From: Harper, Anna [REDACTED]
Sent: 12 August 2022 12:37
To: Anita Gardner <Anita.Gardner@arun.gov.uk>
Subject: RE: Planning Consultation on: LU/144/22/DOC - Condition 7 - Construction Management Plan.

Environmental Health agree to proposed changes to CEMP, LTH-RGP-SW-XX-RP-Y-XX-6809, Revision PO6, dated 27 June 2022, as attached. Once fully applied, I do not anticipate further delay to discharge of Condition 7.

I refer to Construction Environmental Management Plan (Framework) DOC: LTH-RGP-SW-XX-RP-Y-XX-6809 (P05), dated May 2022. I make the following comments:-

Application No: LU/144/22/DOC
Registered: 17th May 2022
Site Address: Land South Of The Littlehampton Academy Fitzalan Road Littlehampton BN17 6ED
Description of Works: Approval of details reserved by condition imposed under ref LU/116/21/PL relating to Condition No 7 - Construction Management Plan.

Fitzalan Road, Littlehampton Progress Dropline

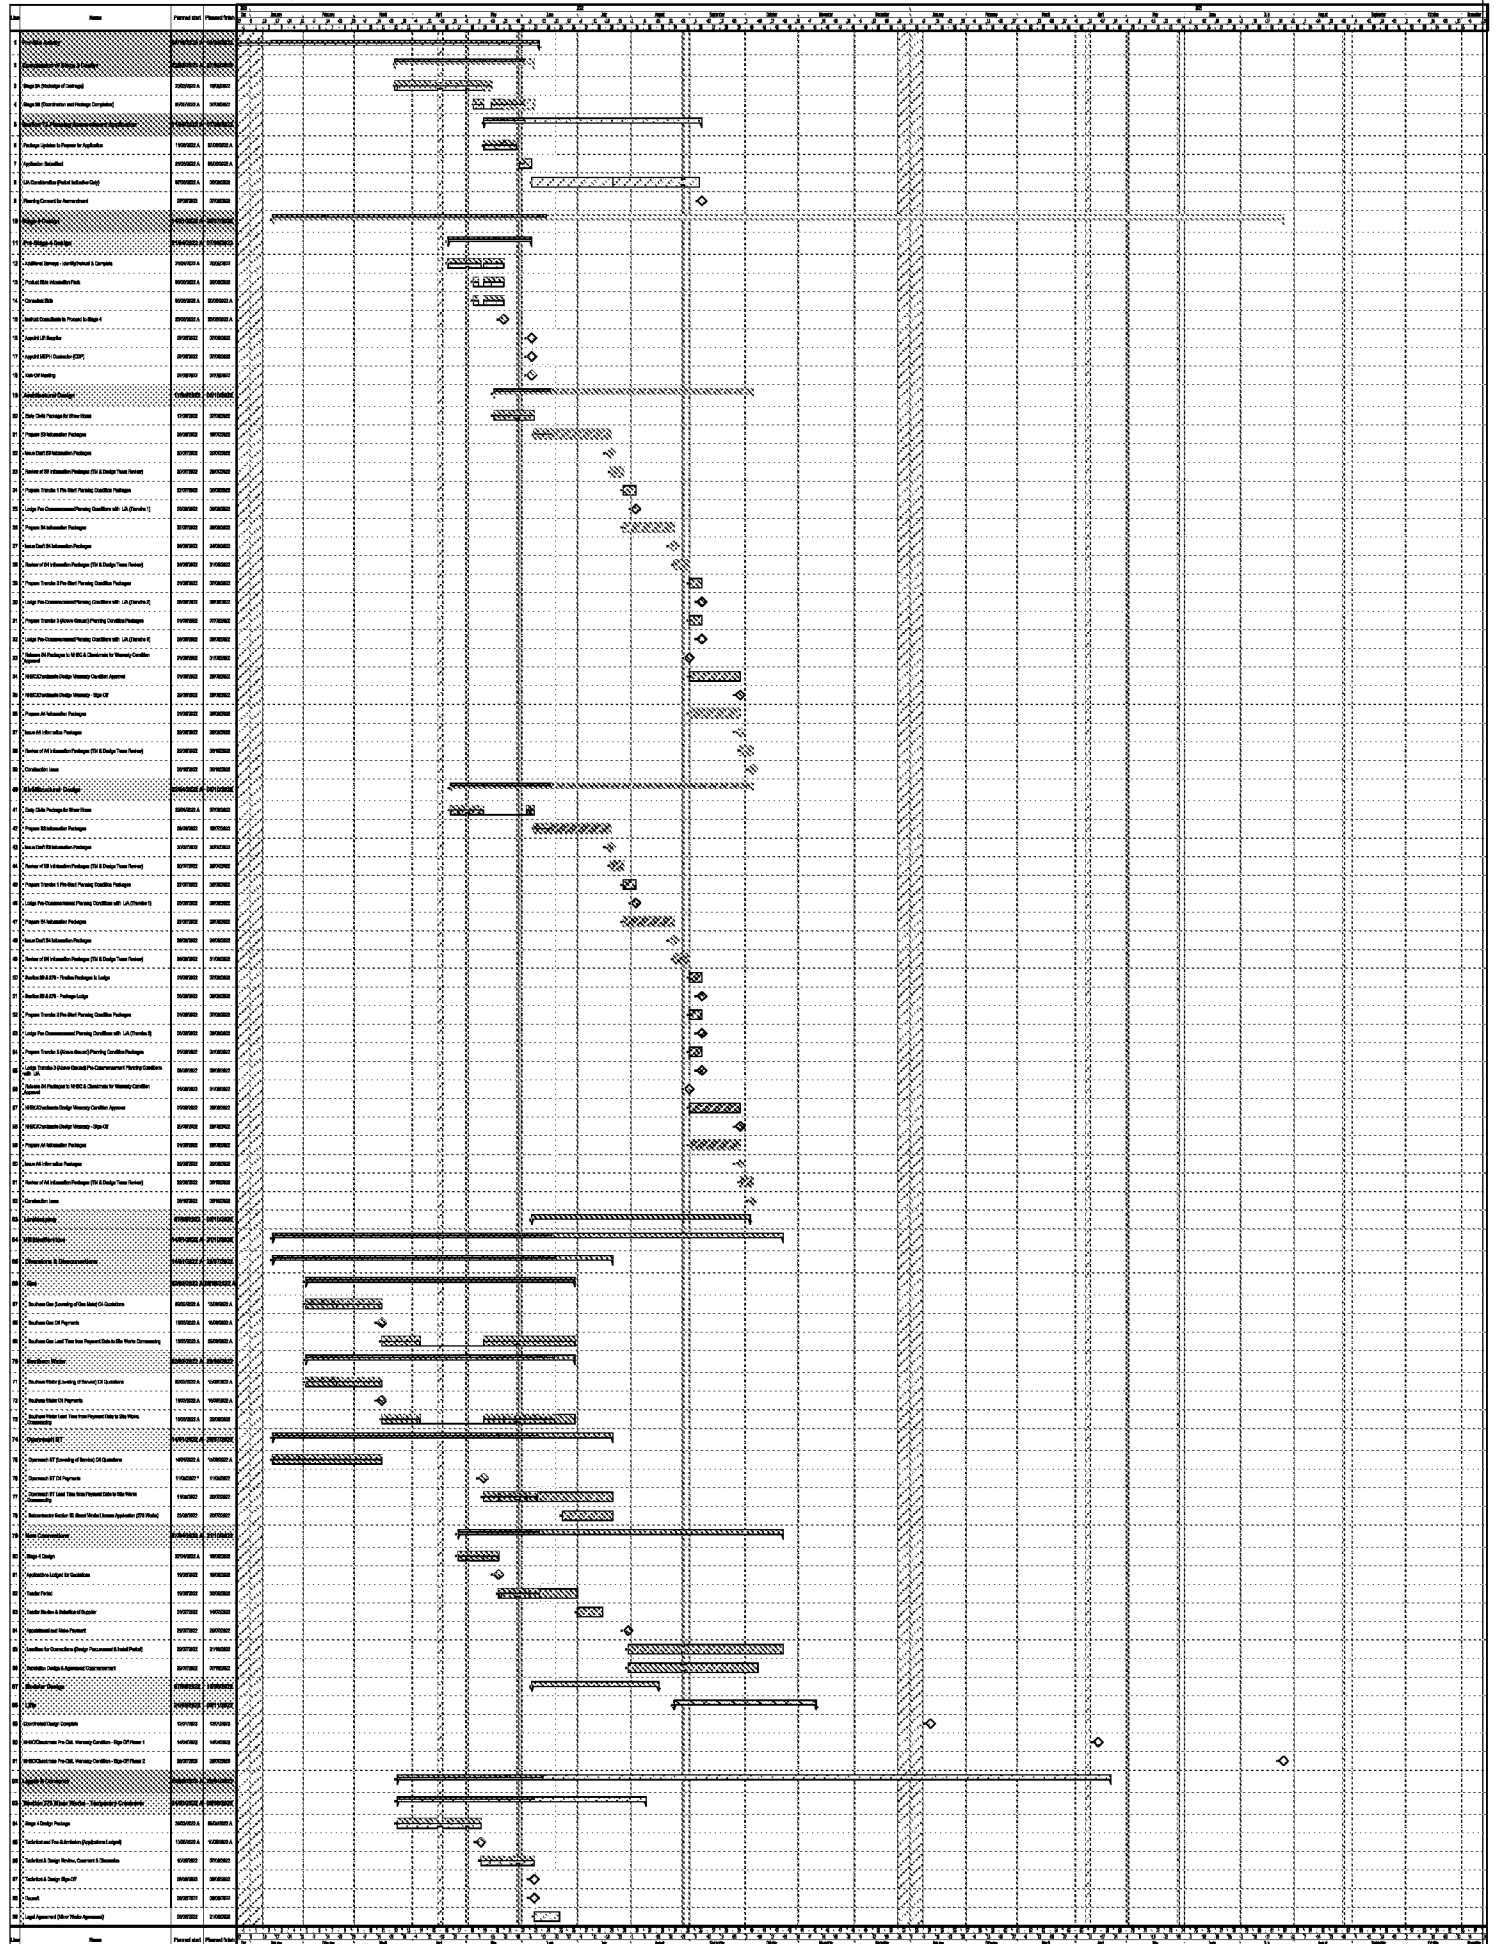
***Continued short term use of Elm Grove Road.** We would accept further use of this road in line with constraints stated in this paragraph and given that these will be properly notified to contractors and applied. However, that such further use shall be completed by no later than 8 August 2022. Unfortunately, it is not possible to read The Progress Dropline which accompanies this CEMP
